CITY OF ALBUQUERQUE

March 12, 2021

Re: Church of Christ
102 Camino De La Sierra NE
Traffic Circulation Layout
Architect's Stamp 03-11-21 (L23-D024A)

TRAFFIC CIRCULATION LAYOUT

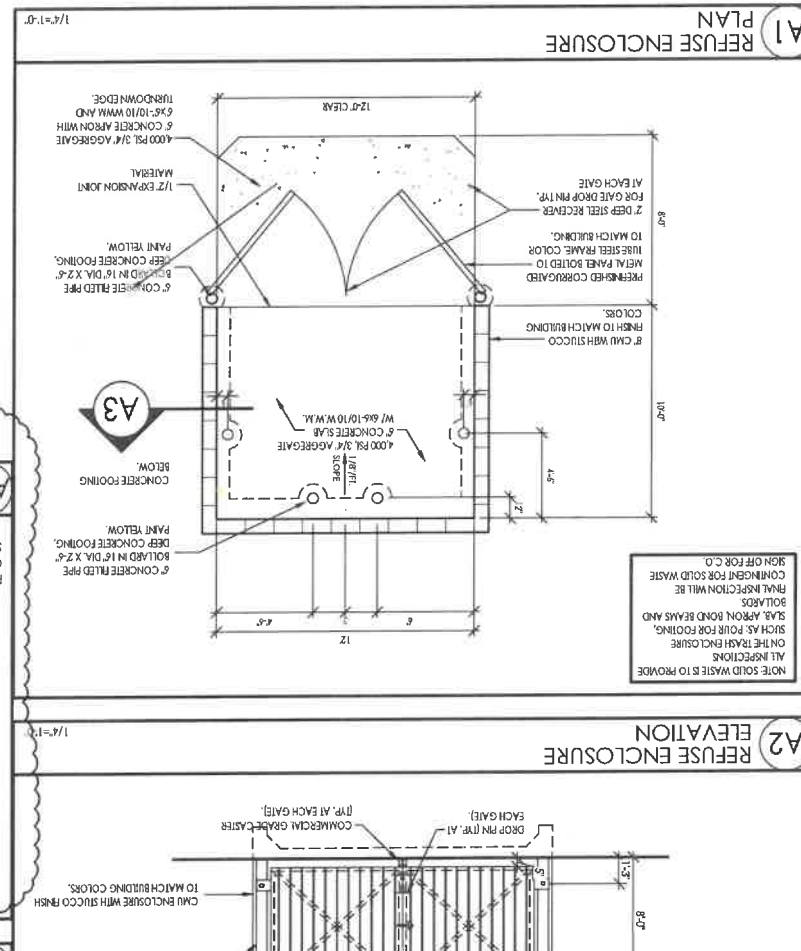
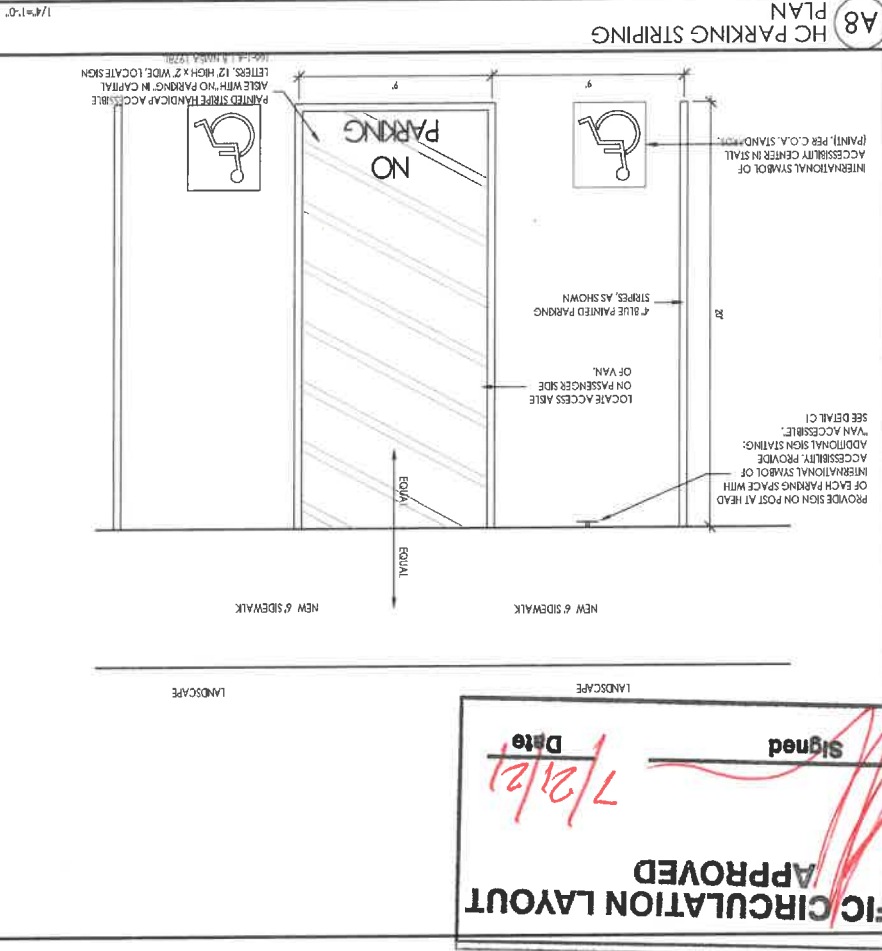
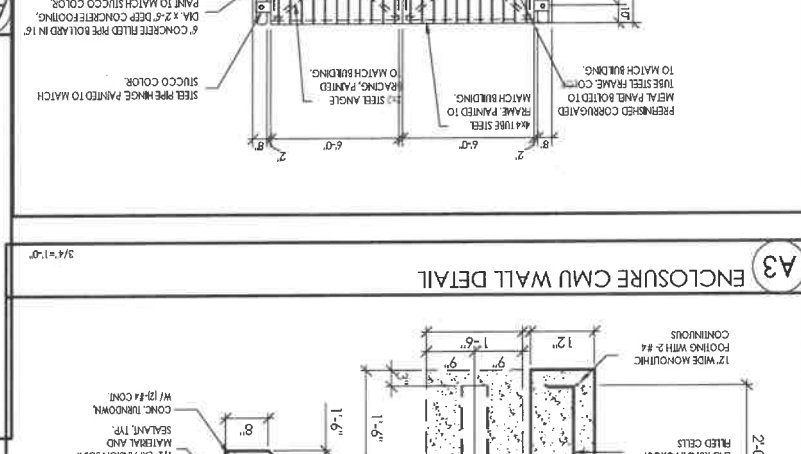
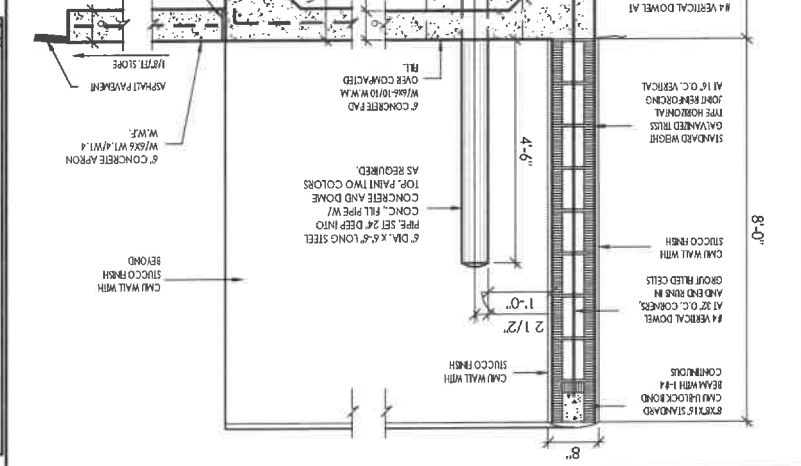
1. List the number of parking spaces required by the IDO as well as the proposed number of parking spaces including bicycle and motorcycle parking.
2. Please identify all existing buildings, doors, structures, sidewalks, curbs, drive pads, wall and anything that influences the parking and circulation on the site.
3. Identify all existing access easements and rights of way width dimensions (If applicable).
4. What is the status of public sidewalk on the frontage of Camino de la Sierra beyond the 24 ft entrance? You will need to provide sidewalk on the whole length of the street frontage.
5. All sidewalks along streets should be placed at the property line.
6. Required dimensions for low density driveways are:

8. Please list the width for all proposed parking spaces. Some dimensions are not shown.
9. The minimum parking stall dimensions are:

10. The ADA accessible spaces must include an access aisle. Van accessible aisles should be 8ft wide; all others should be 5ft wide.
11. ADA curb ramps must be meet the updated to current standards on the site. This includes the width.
12. Motorcycle parking spaces shall be designated by its own conspicuously posted upright sign, either free-standing or wall mounted per the zoning code. Please label pavement MC.
13. Show all drive aisle widths and radii. Some dimensions are not shown.
14. The minimum drive aisle dimensions are shown below

15. List radii for all curves shown; for passenger vehicles. Radius for delivery trucks, fire trucks, etc. is 25 ft. or larger.
16. Per the IDO, a 6 ft. wide ADA accessible pedestrian pathway is required from the public sidewalk to the building entrances. Please clearly show this pathway.
17. Per DPM, a 6 ft. wide ADA accessible pedestrian pathway is required from the ADA parking stall access aisles to the building entrances. Please clearly show this pathway.
18. Provide a copy of refuse approval.
19. It is not apparent what thickness of asphalt pavement surface is being proposed.
20. Please provide a sight distance exhibit

21. Show the clear sight triangle and add the following note to the plan: "Landscaping and signage will not interfere with clear sight requirements. Therefore, signs, walls, trees, and shrubbery between 3 and 8 feet tall (as measured from the gutter pan) will not be acceptable in the clear sight triangle.

22. Please specify the City Standard Drawing Number when applicable.
If applicable (notes 23, 24 & 25)
23. Provide notes showing what work is included and on the work order and the private work on site.

24. Work within the public right of way requires a work order with DRC approved plans.
25. Please add a note on the plan stating "All improvements located in the Right of Way must be included on the work order."

26. Add a note stating "All broken or cracked sidewalk must be replaced with sidewalk and curb & gutter." A build note must be provided referring to the appropriate City Standard drawing.
